FORMAL STRATEGIC OBJECTION: STATE SIGNIFICANT DEVELOPMENT

Development Project: 138 Maroubra Road Mixed-Use Proposal (SSD-81426710)

Objecting Party: Surrounding Locality Residents & Adjoining Neighbours

DRAWN BY	SCALE	SHEET SIZE	PRINT DATE
Author	1:100	A1	18/09/2025
DESCRIPTION			5:09:04 PM
GROUND FLOOR PLAN			
PROJECT No	DRAWING No	REVISION	
21_435	DA1.104	V

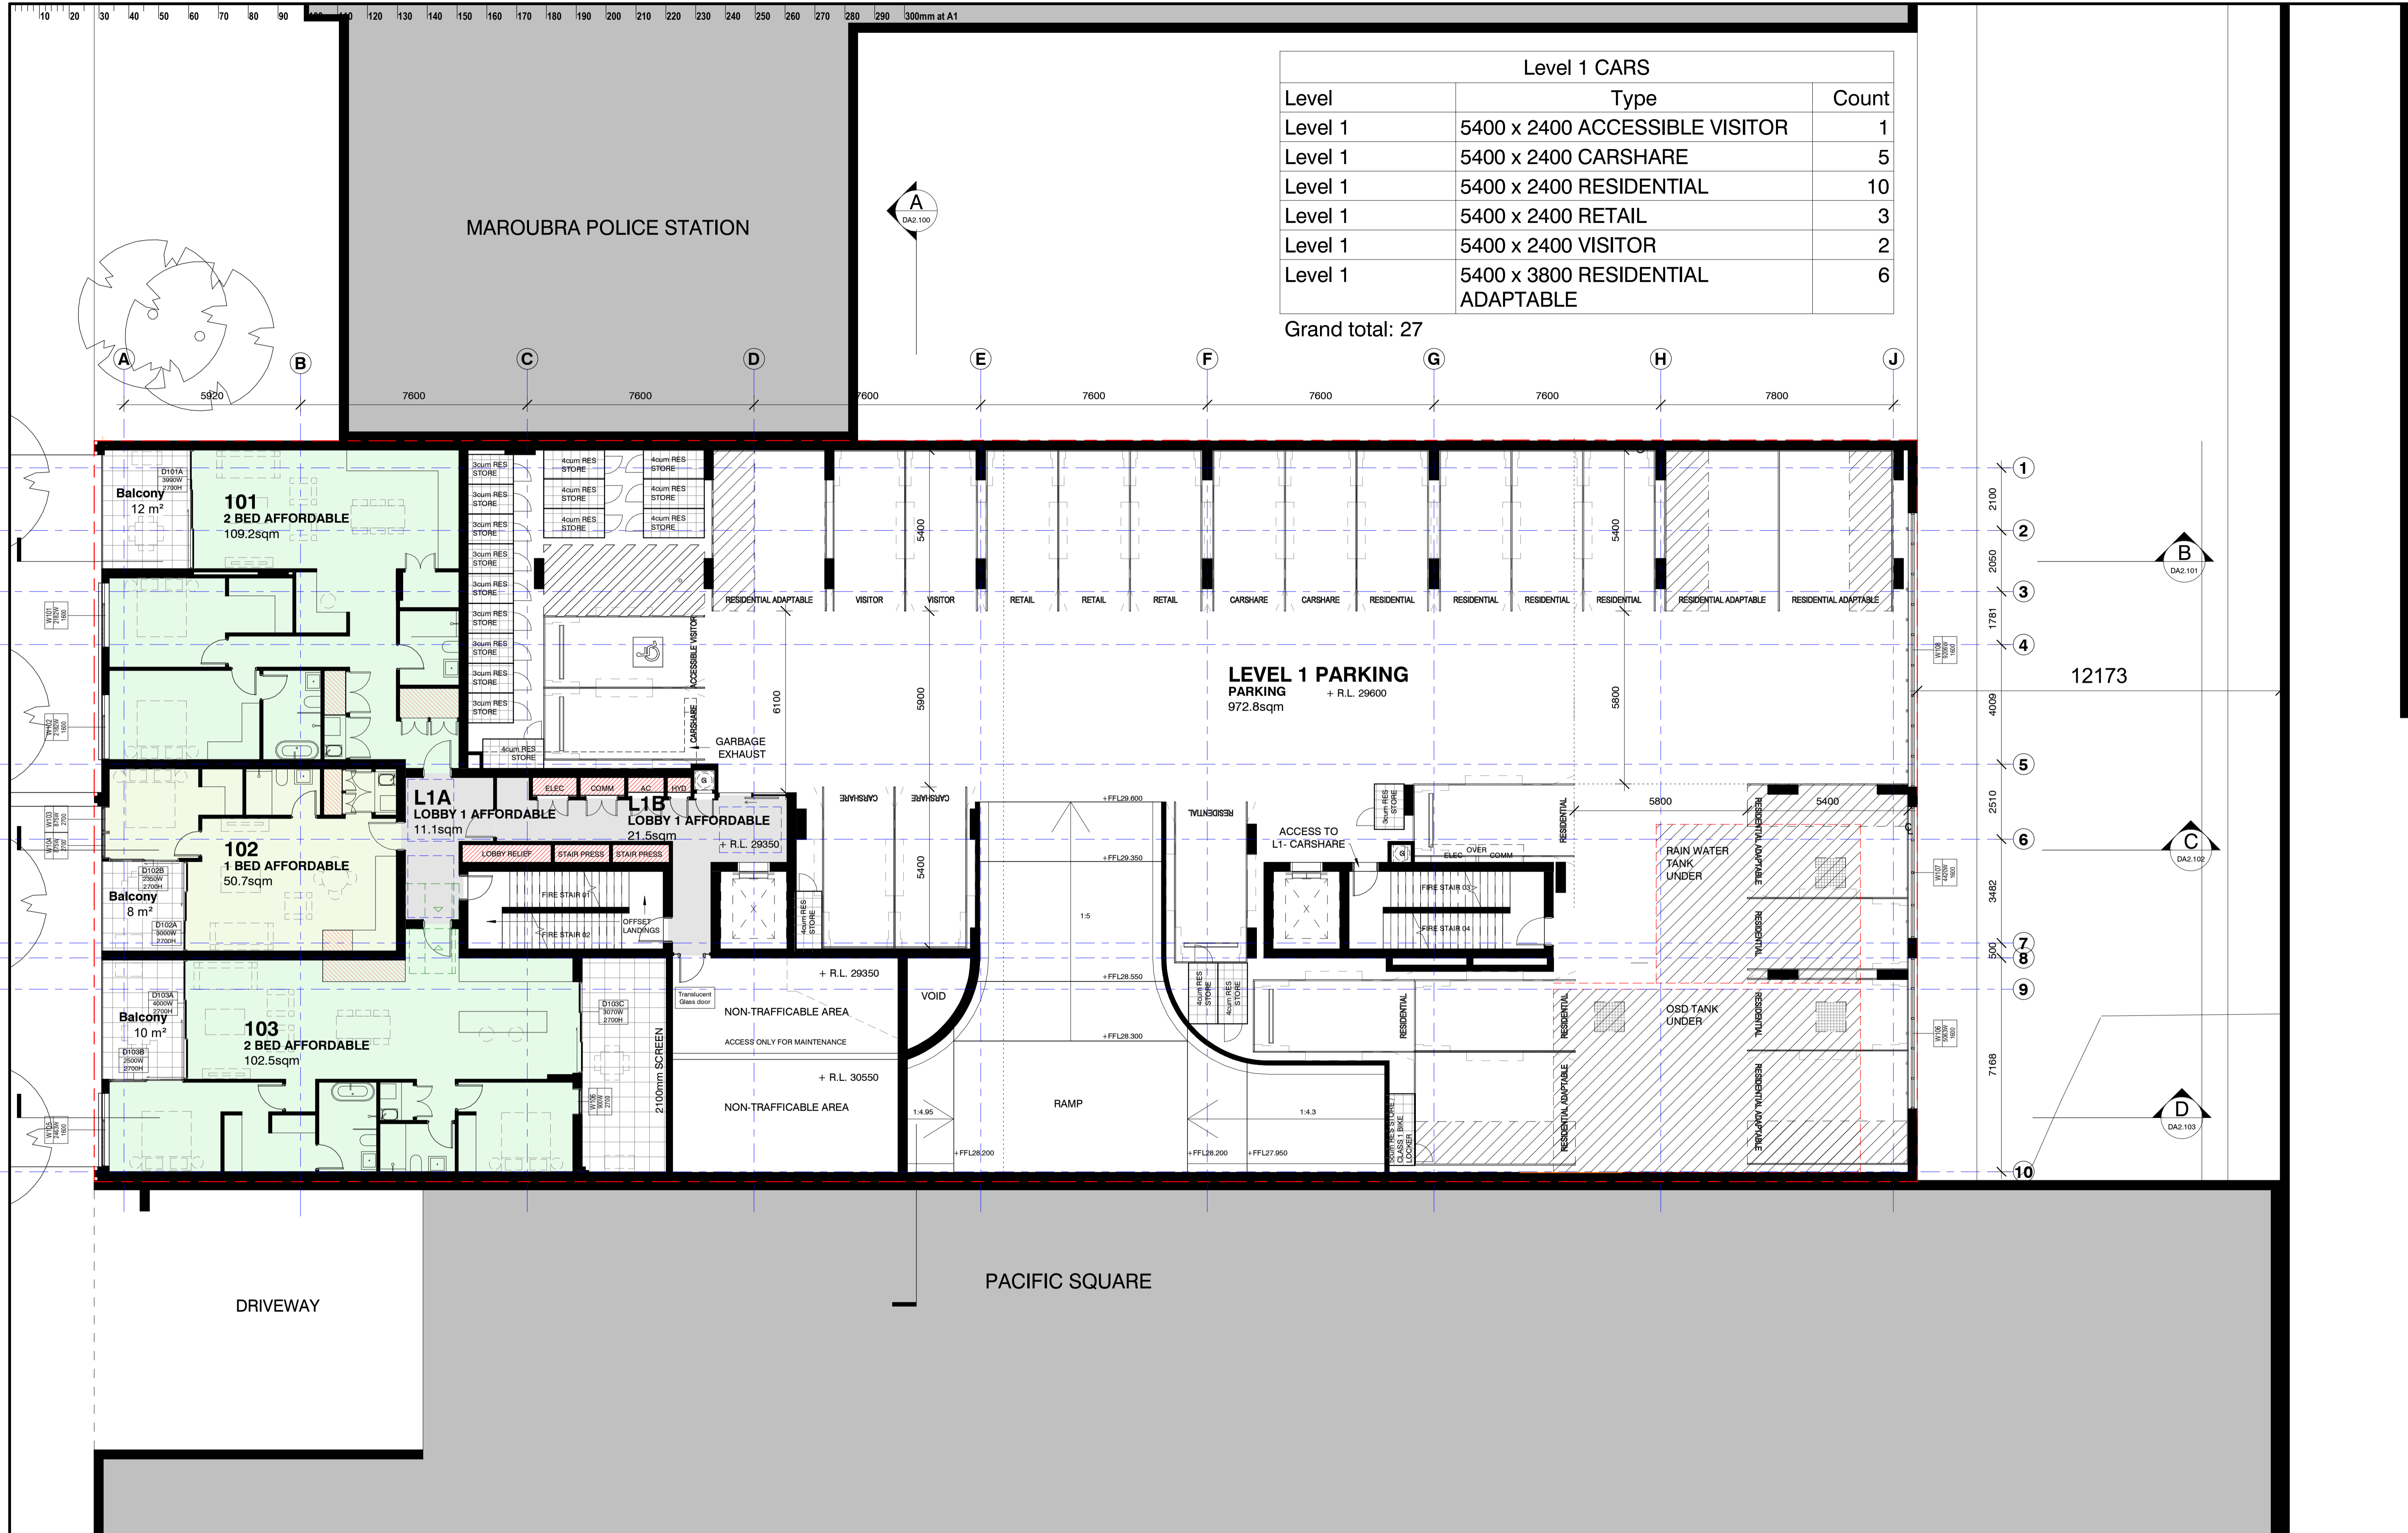
The modified layout entirely shifts the development's operational traffic burden by directing 100% of residential parking ingress, visitor vehicles, service fleets, and waste collection to the rear via Piccadilly Place. This design choice ignores the acute physical constraints of the rear thoroughfare.

Piccadilly Place and its connecting roundabout are already operating at capacity due to the continuous heavy commercial deliveries required by Pacific Square. Injecting an entire 10-storey development's traffic load directly into this single lane will paralyze local movement. For nearby residents, this introduces ongoing acoustic disruption, while presenting an immediate collision hazard for the numerous community members—most notably the extensive population of elderly neighbors—who walk through this flat precinct daily for essential shopping and medical care.

DRAWN BY	SCALE	SHEET SIZE	PRINT DATE
Author	1:100	A1	18/09/2025
DESCRIPTION			REVISION
WEST ELEVATION			5:15:36 PM
PROJECT No	DRAWING No	REVISION	
21_435	DA2.203	N

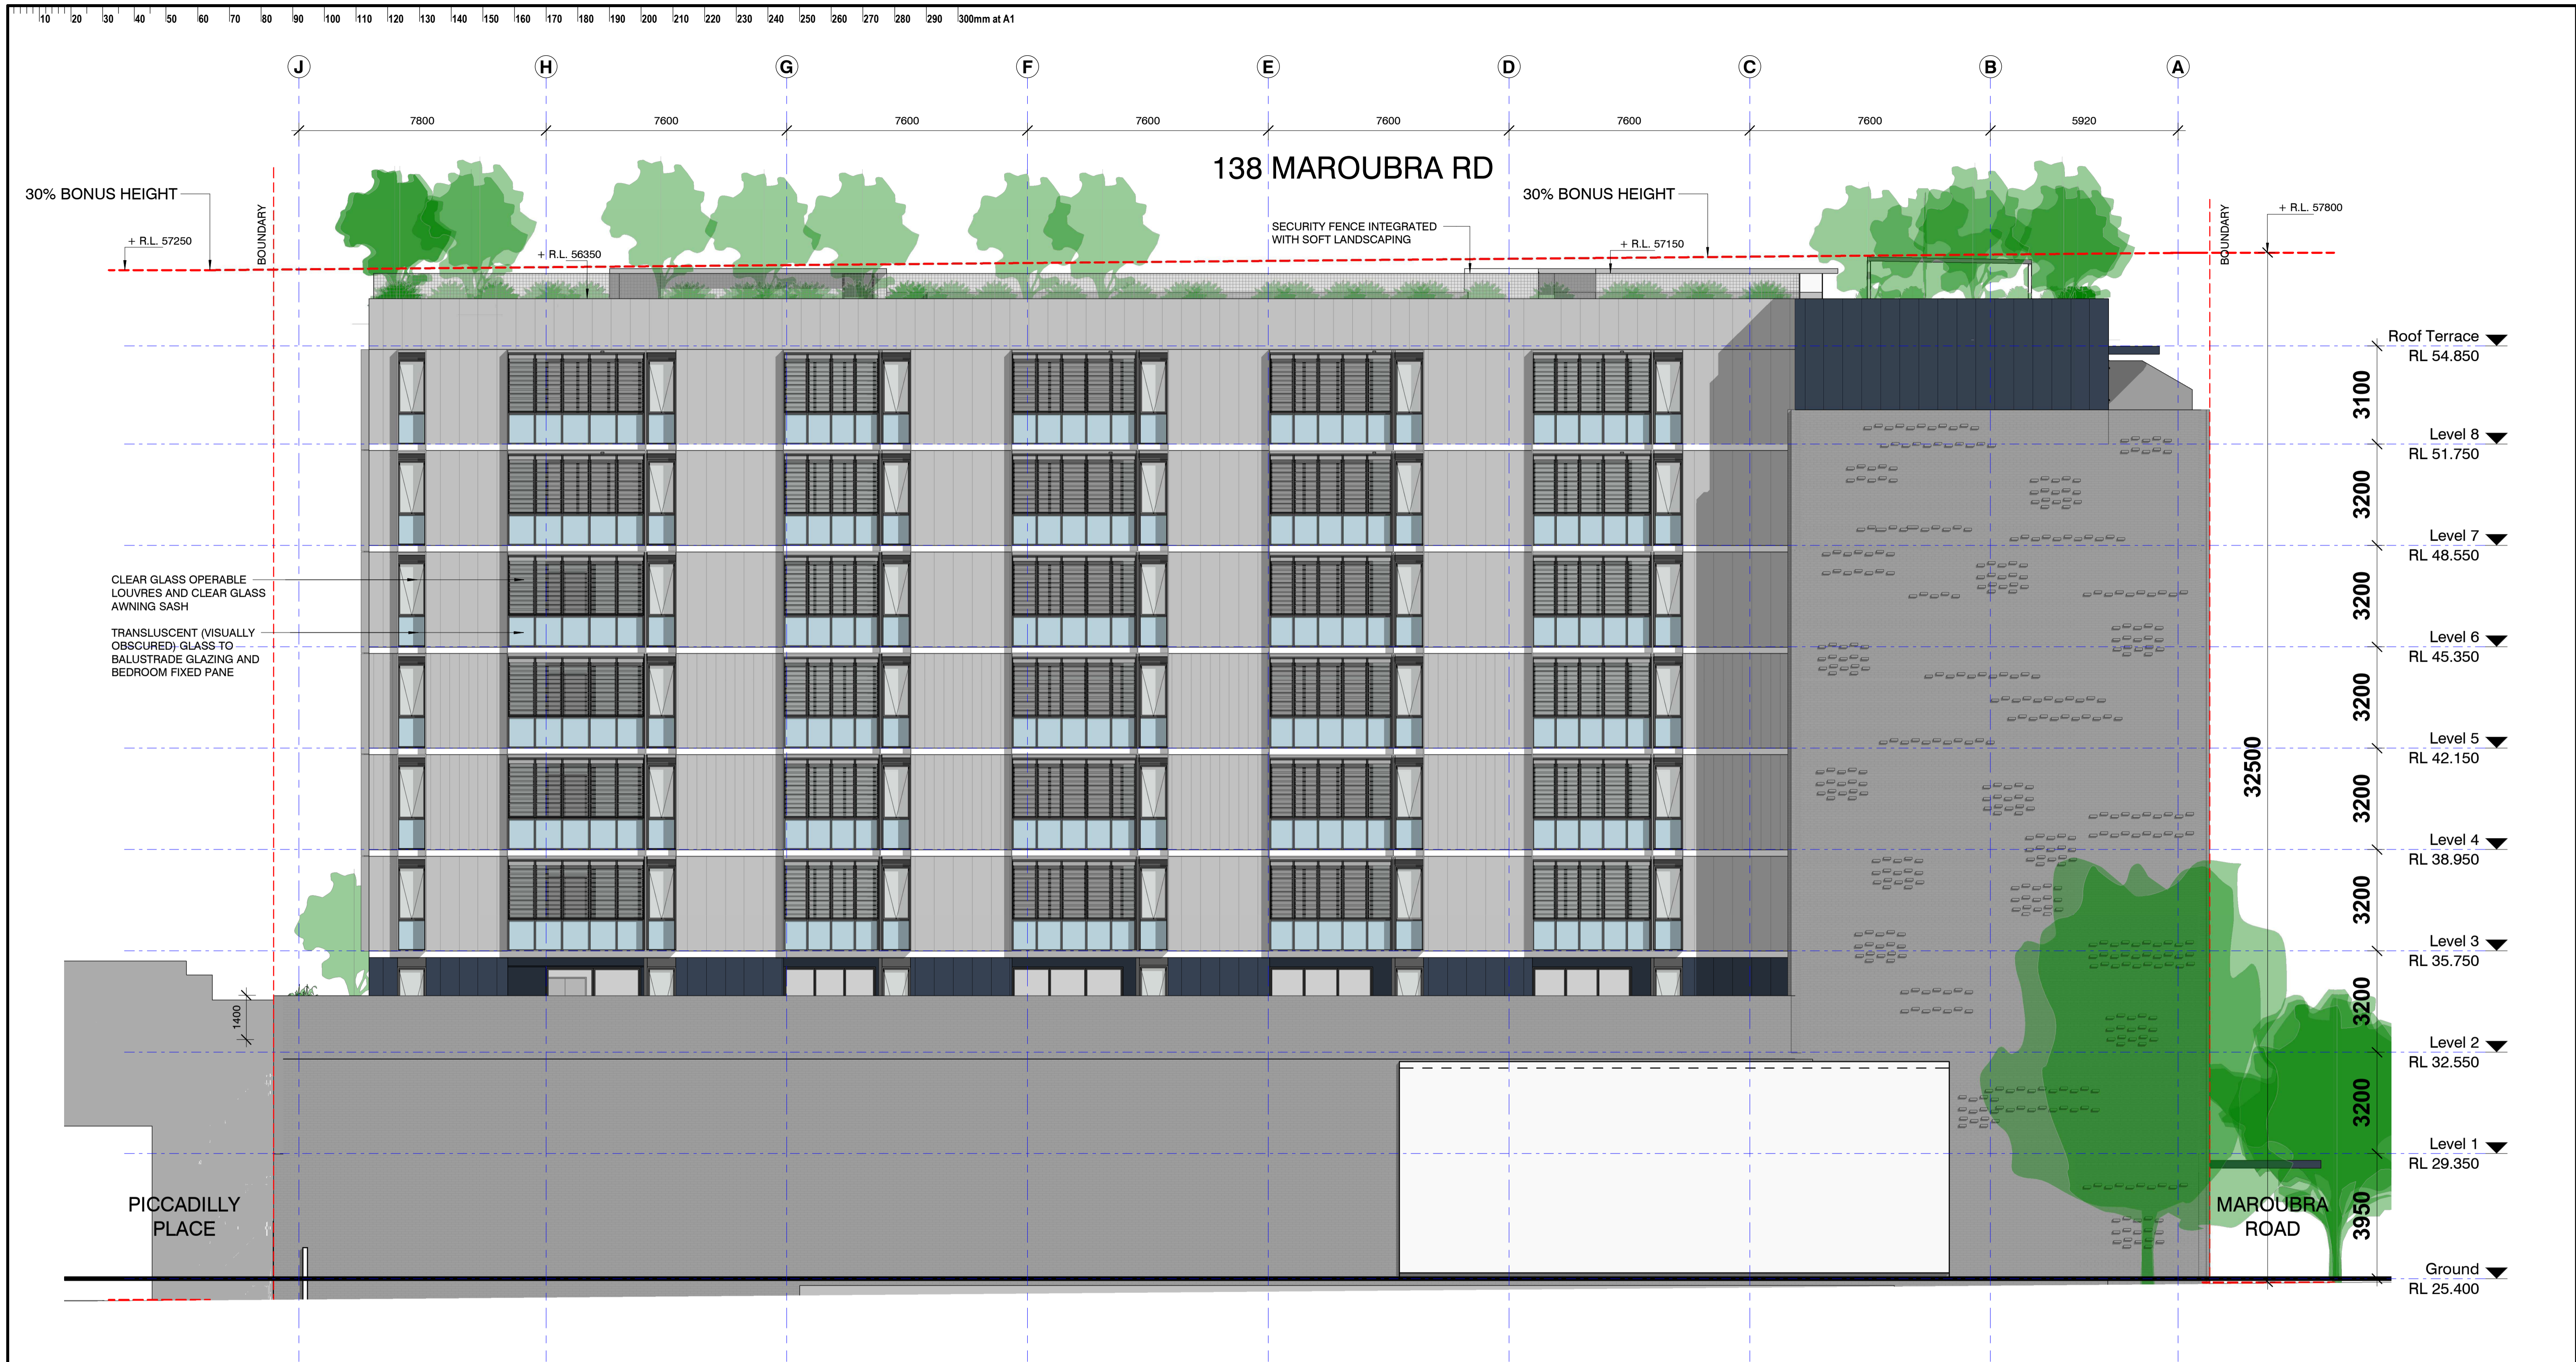
By erecting a flat, unstepped 32.5-meter raw concrete wall right up to the shared eastern boundary line, the design forces permanent visual claustrophobia onto adjoining homes. Residents will be forced to look directly at a monolithic 10-storey concrete wall outside their windows, severely reducing natural cross-ventilation, destroying spatial openness, and directly harming local residential livability.
